From: [REDACTED]
Sent: 28 November 2017 12:38
To: Ross Leal
Subject: Re: FP/273/17/CLP - 19 Homefield Avenue, Felpham

From: Ross Leal [REDACTED]
To: 'ROGERSBigtone@aol.com' <[REDACTED]>
Sent: Tue, 28 Nov 2017 12:36
Subject: FP/273/17/CLP - 19 Homefield Avenue, Felpham

| Drawing No:                                                                                                                                                         | 16/1235/02            |

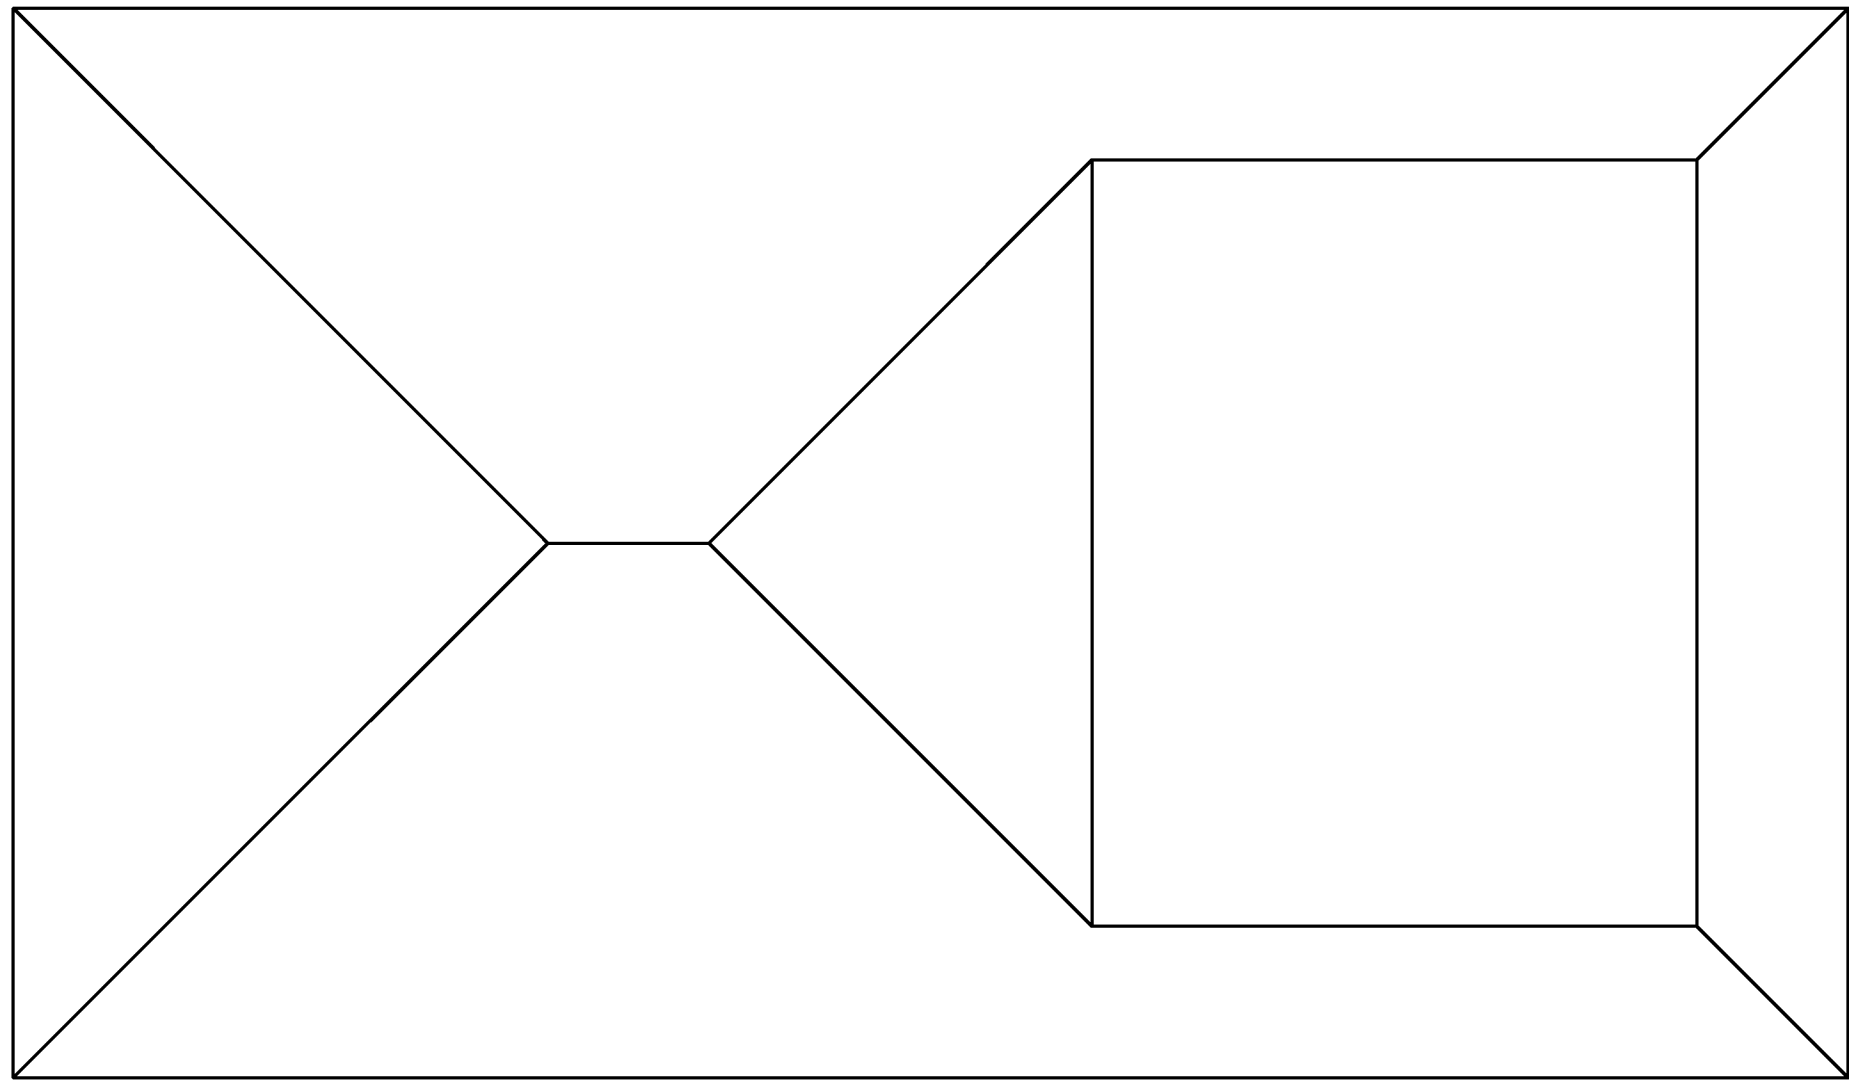
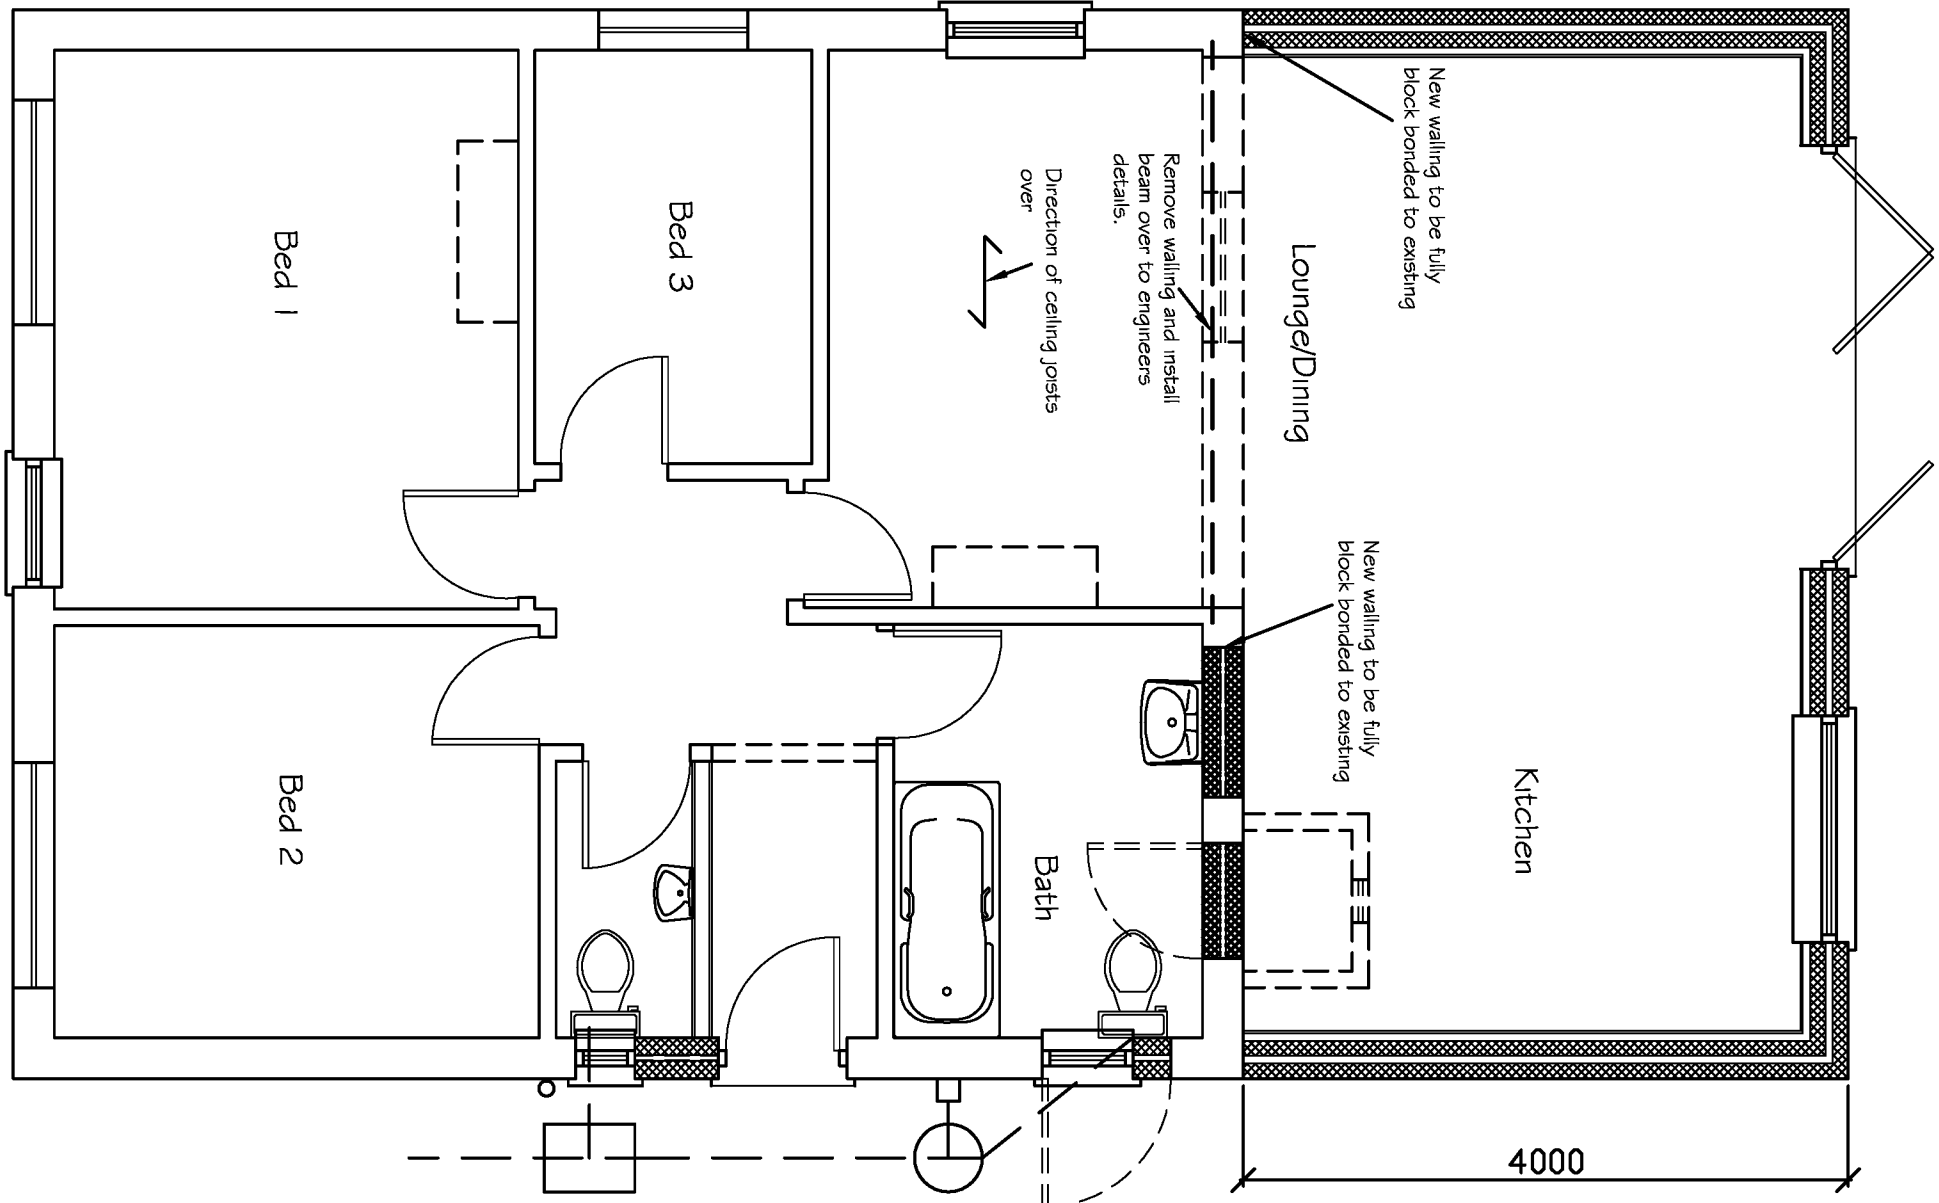
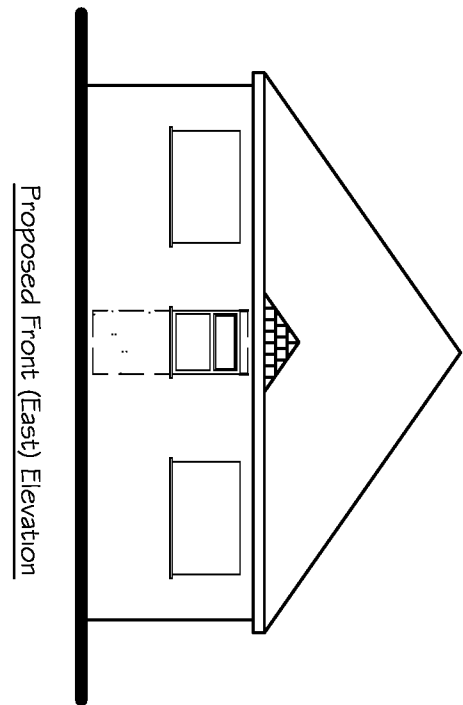
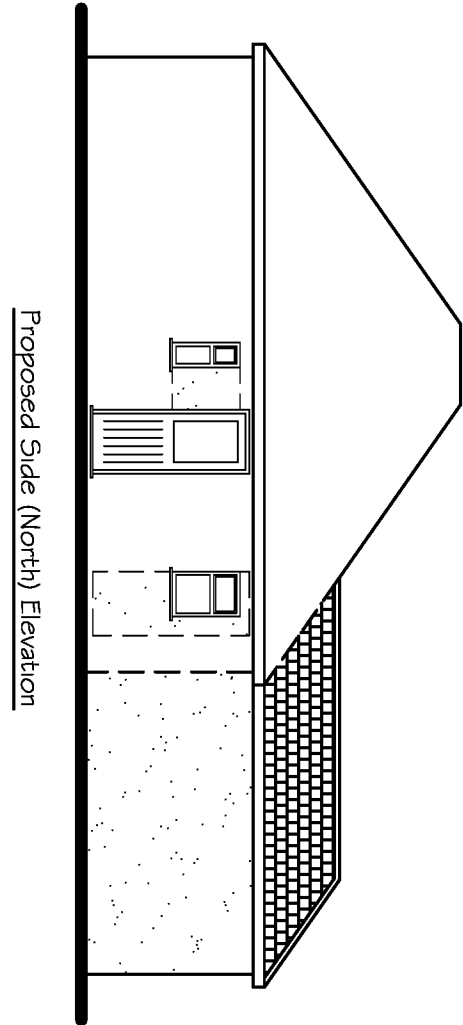
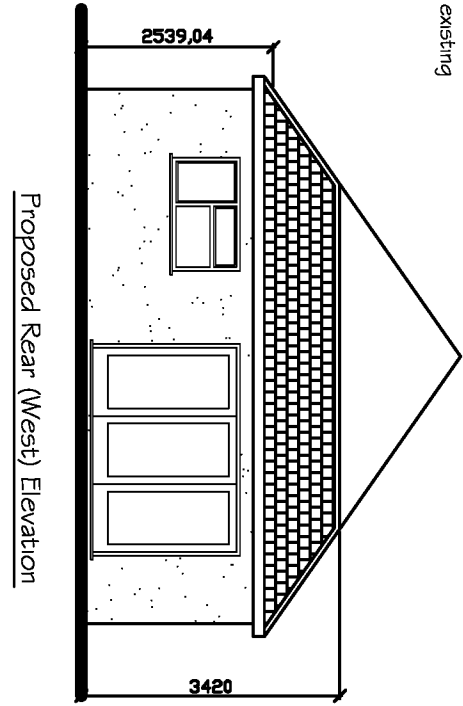
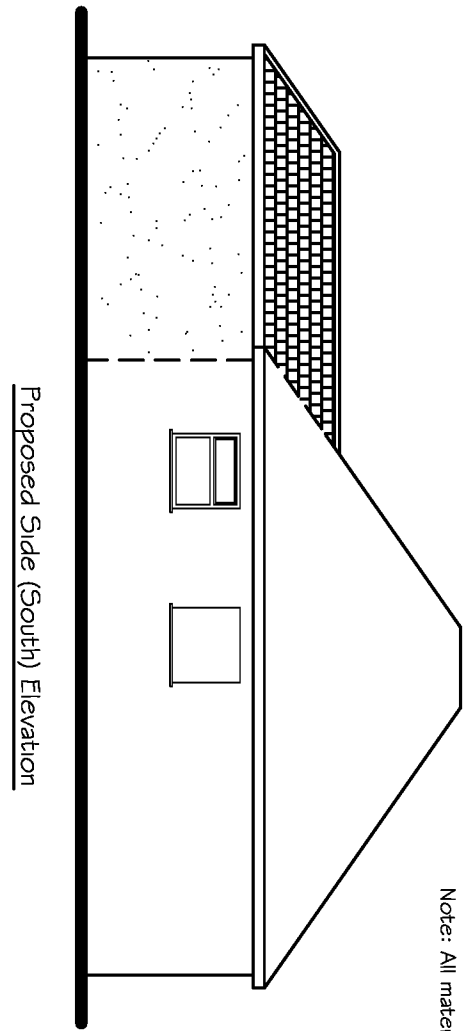
It is not apparent from your application what is proposed in terms of materials. Whilst I have not completed checking your proposal in terms of whether PP is required or not, it would be helpful to know whether:

'The materials used in any exterior work shall be of a similar appearance to those used in the construction of the exterior of the existing dwellinghouse'

If you could specify external finishes then that would be helpful.

I can confirm that all materials will match the existing.
